# CITY OF PORTLAND BUILDING PERMIT

Job ID: 2011-09-2271-CH OF USE

has permission to Do 1st floor restaurant fit up, 24'x17.5' rear deck with landing & steps, add steps to rear of ramp  
provided that the person or persons, firm or corporation accepting this permit shall comply with all of the provisions of  
the Statues of Maine and of the Ordinances of the City of Portland regulating the construction, maintenance and use of  
the buildings and structures, and of the application on file in the department.

Job ID: 2011-09-2271-CH OF USE

**2** SECTION AT NEW STAIR  
 SCALE: 1/2" = 1'-0"

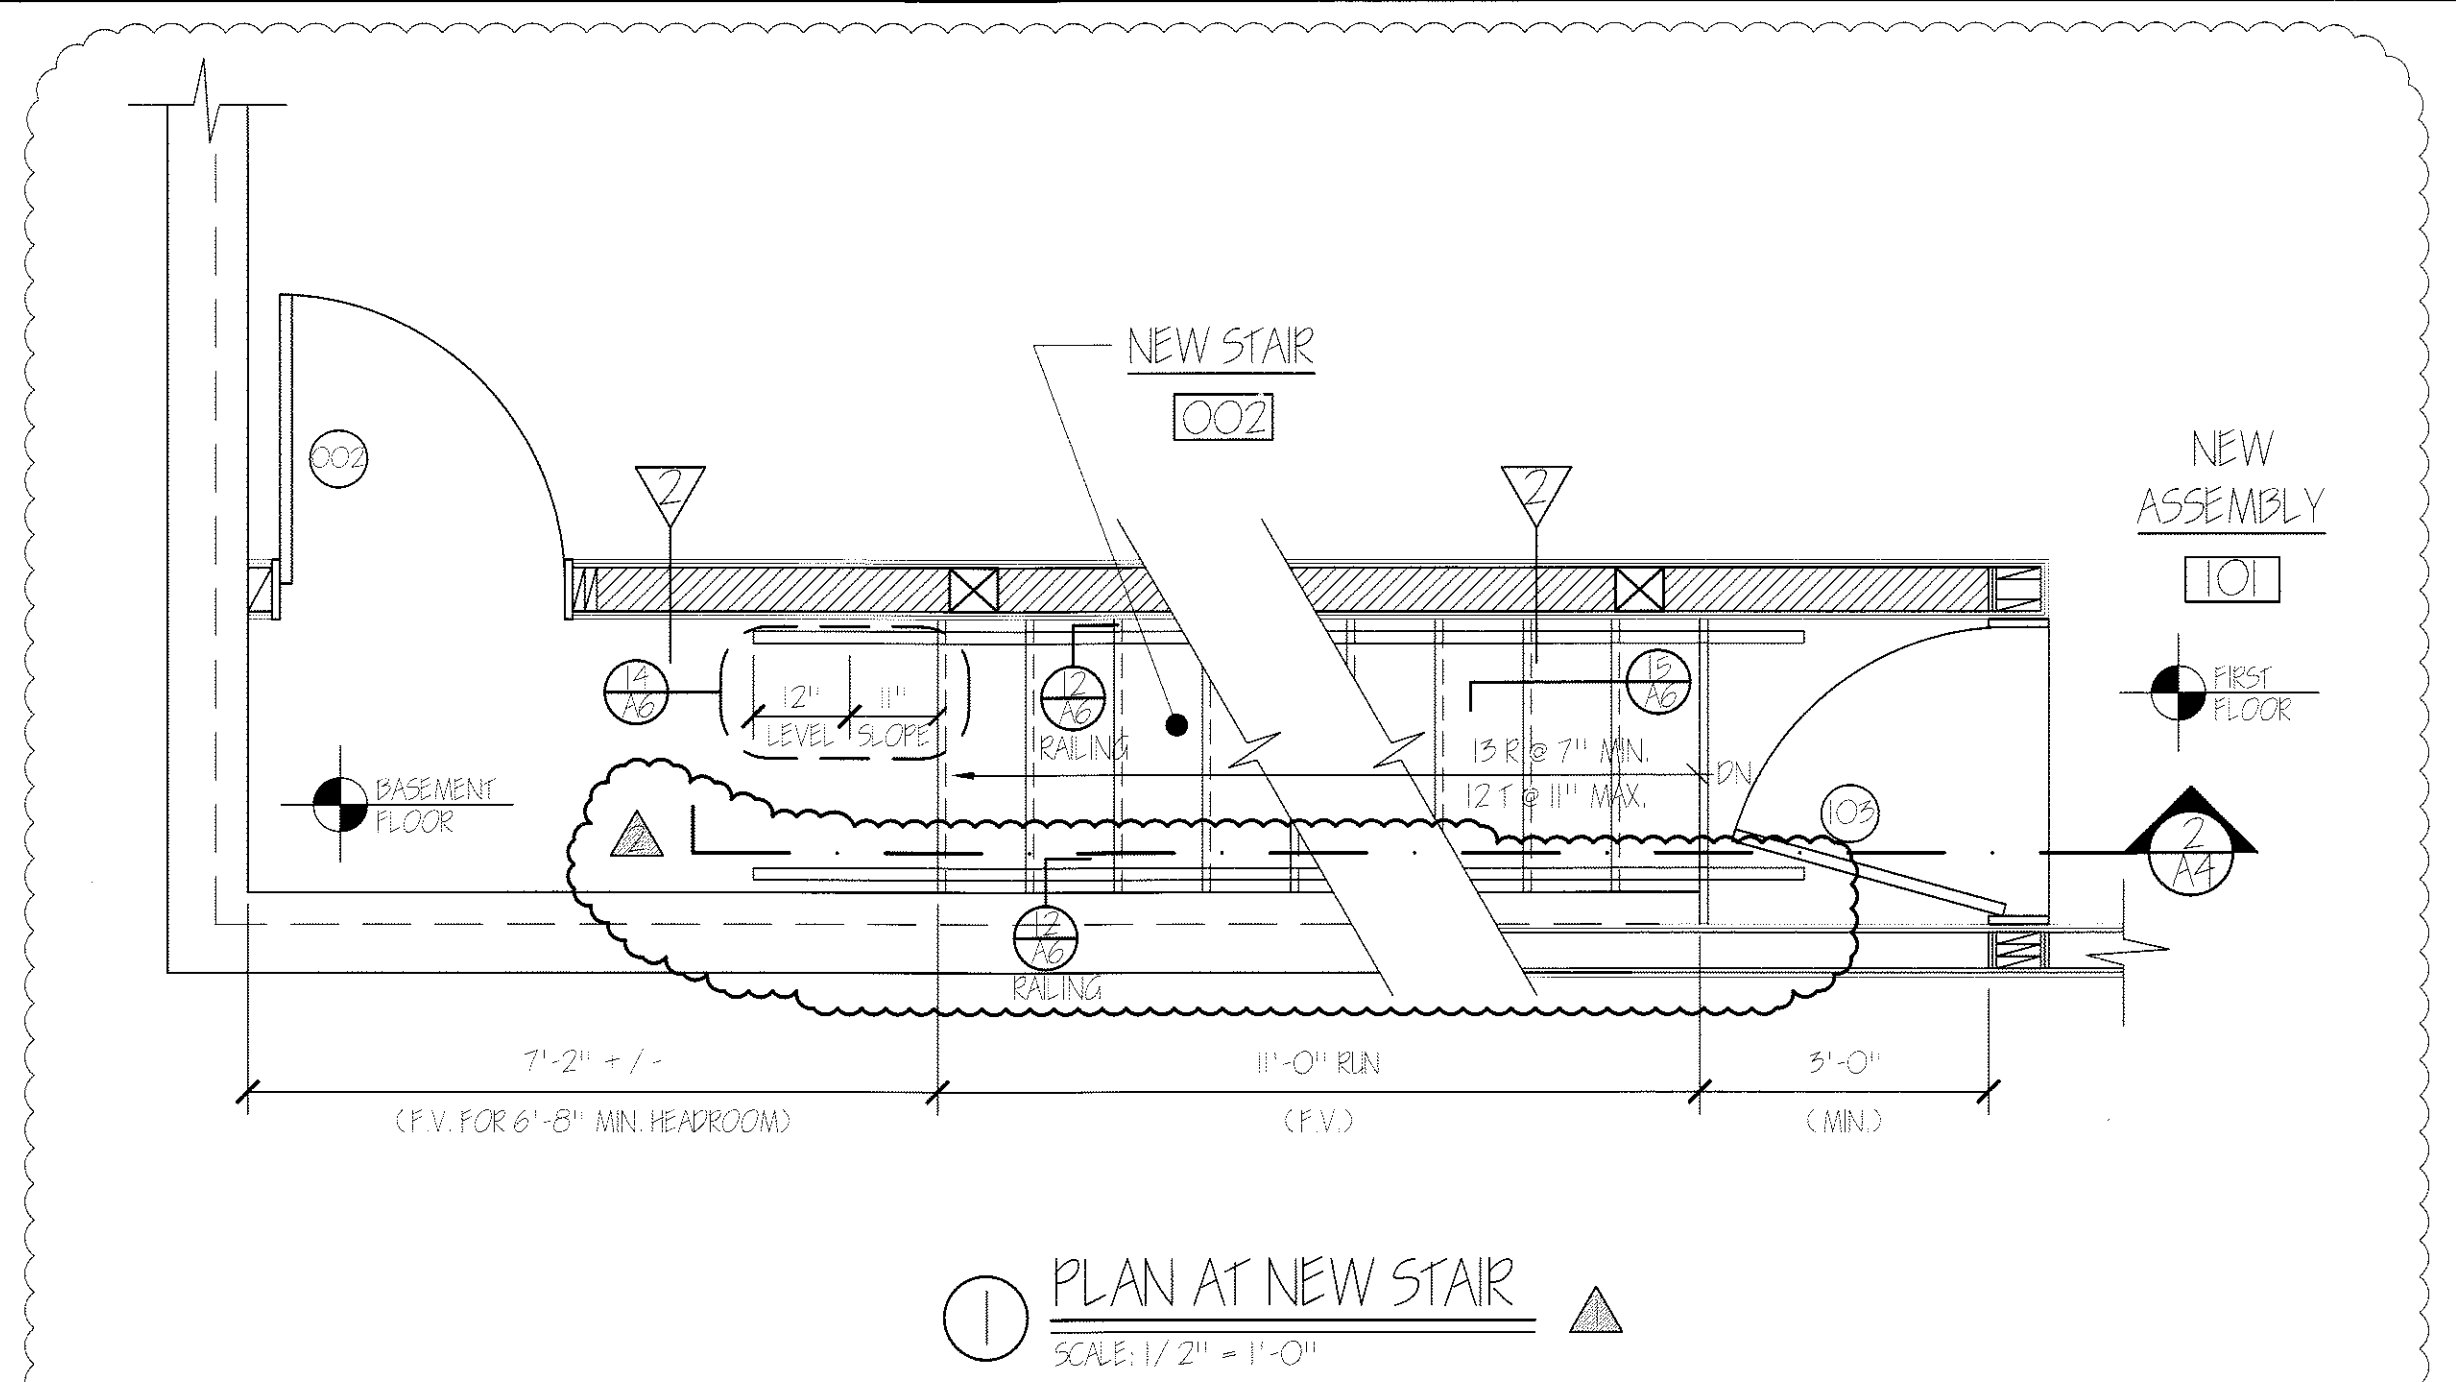
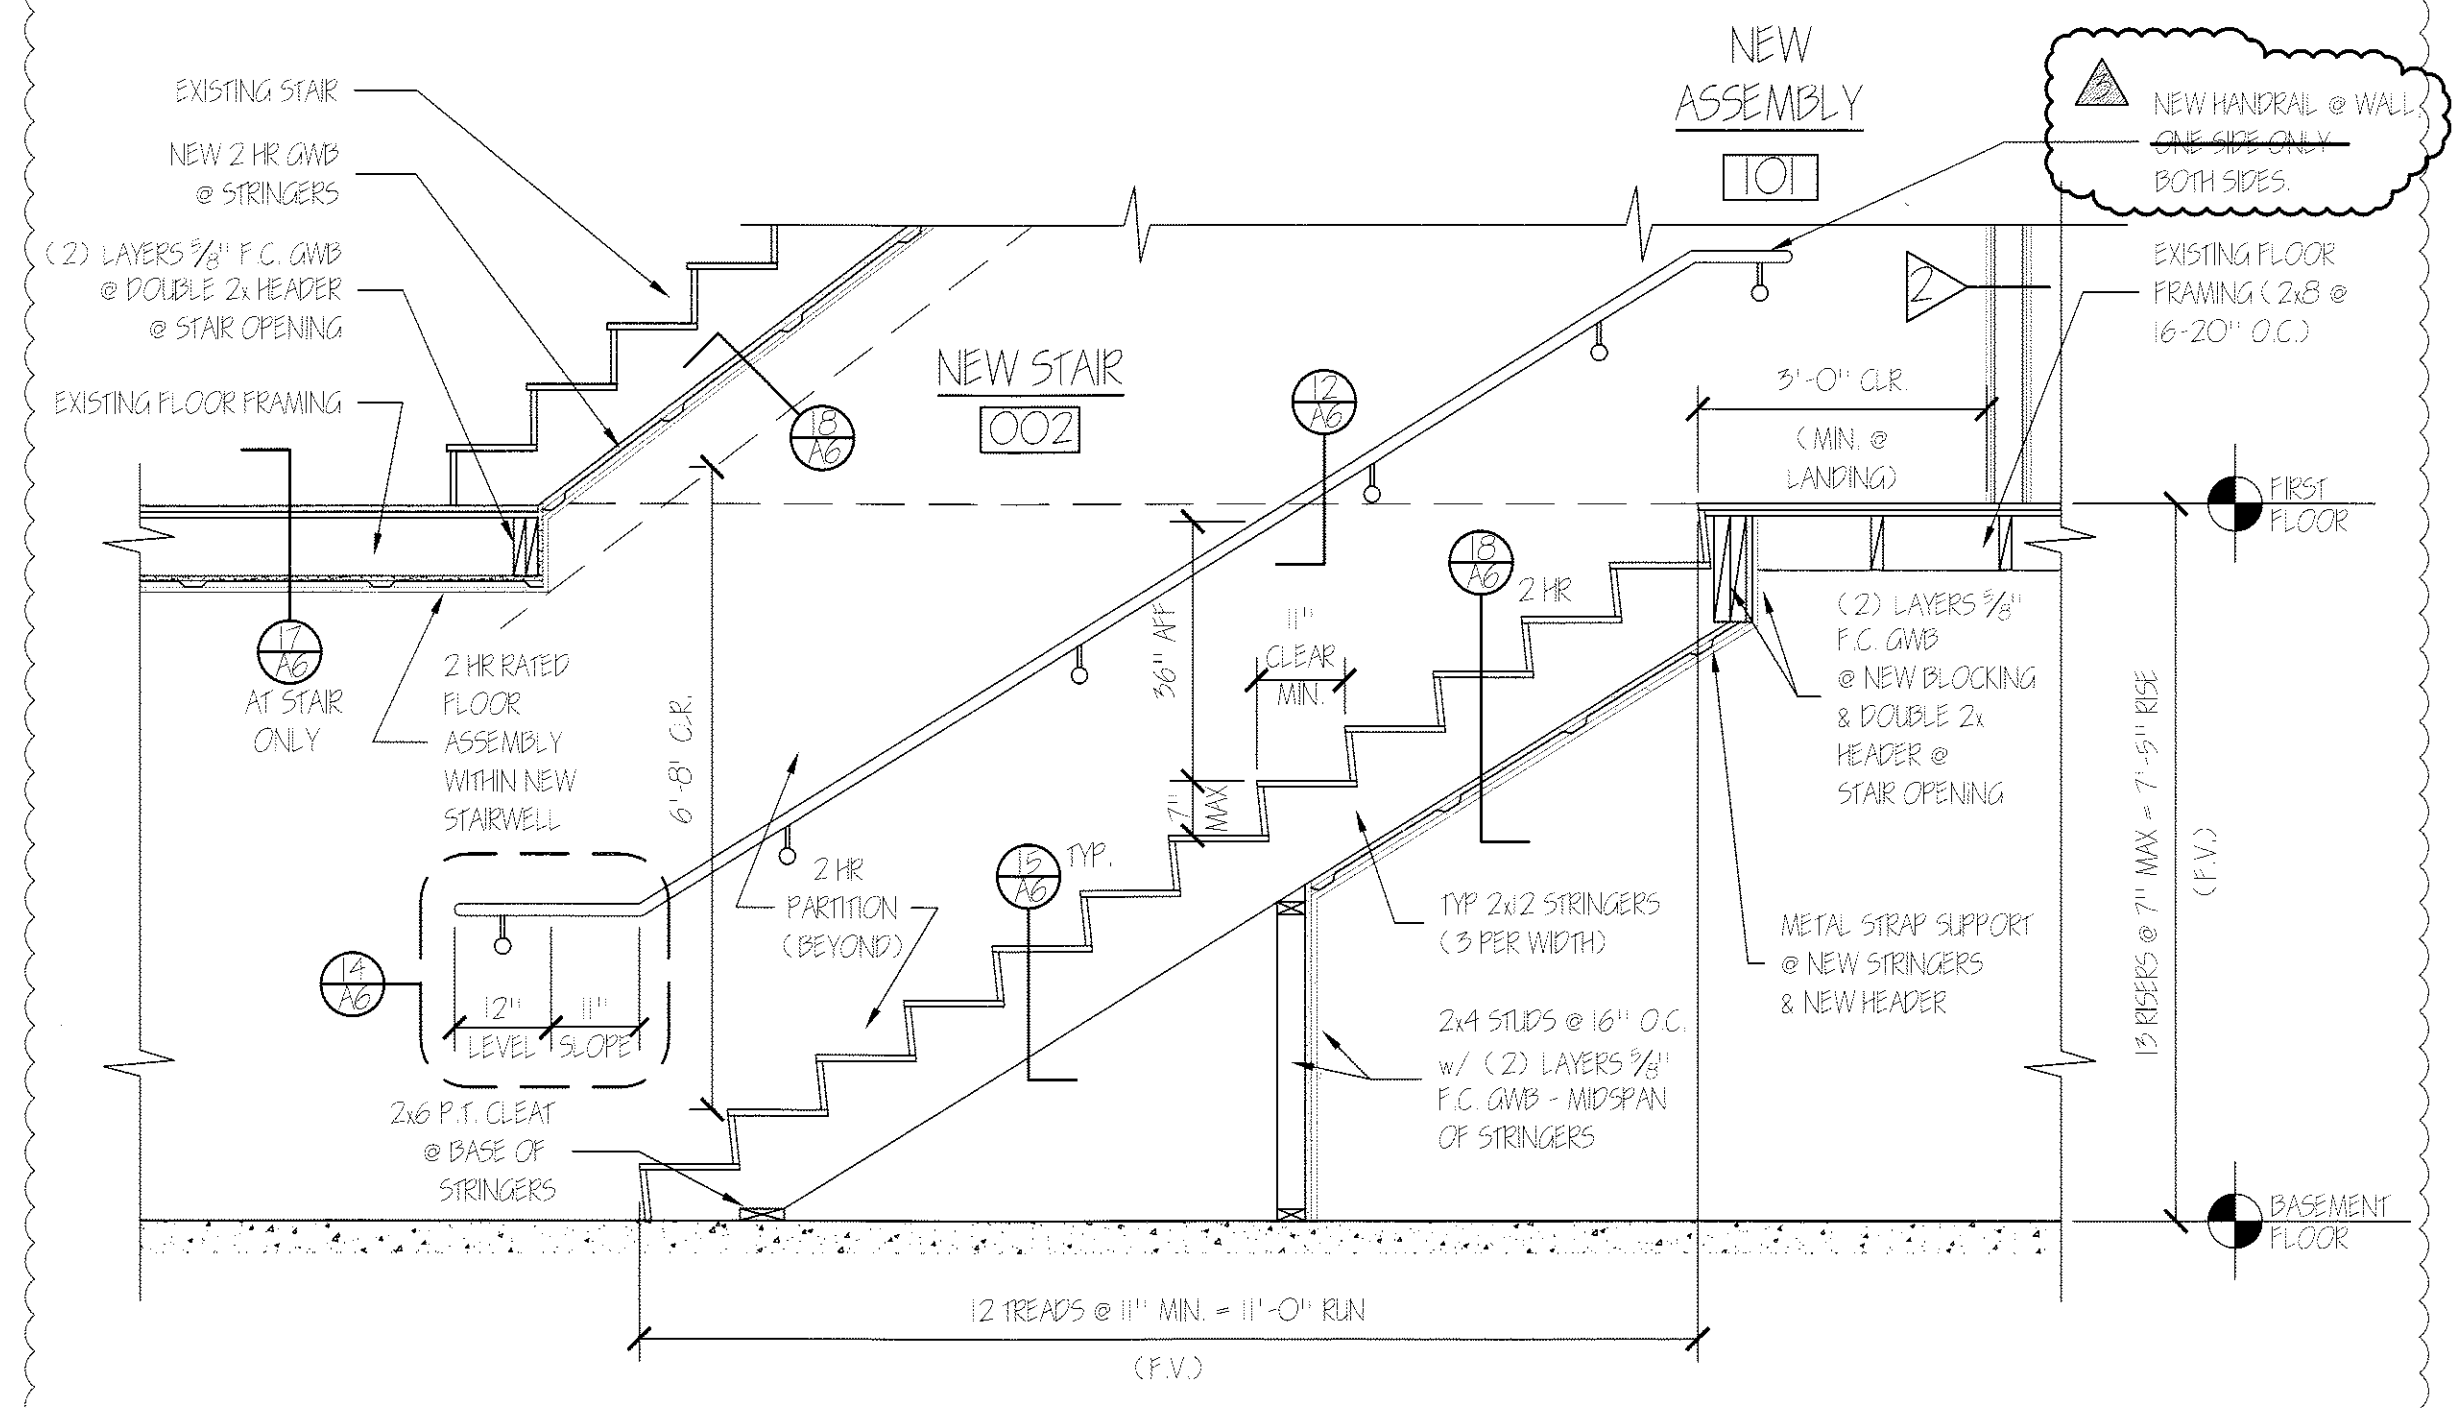
5. Equipment must be installed in compliance per the manufacturer's specifications.
6. The following details were agreed on with Mike H. on 10/21/11:
  - The stair profile detail shall be 90 degrees with no nosing projection
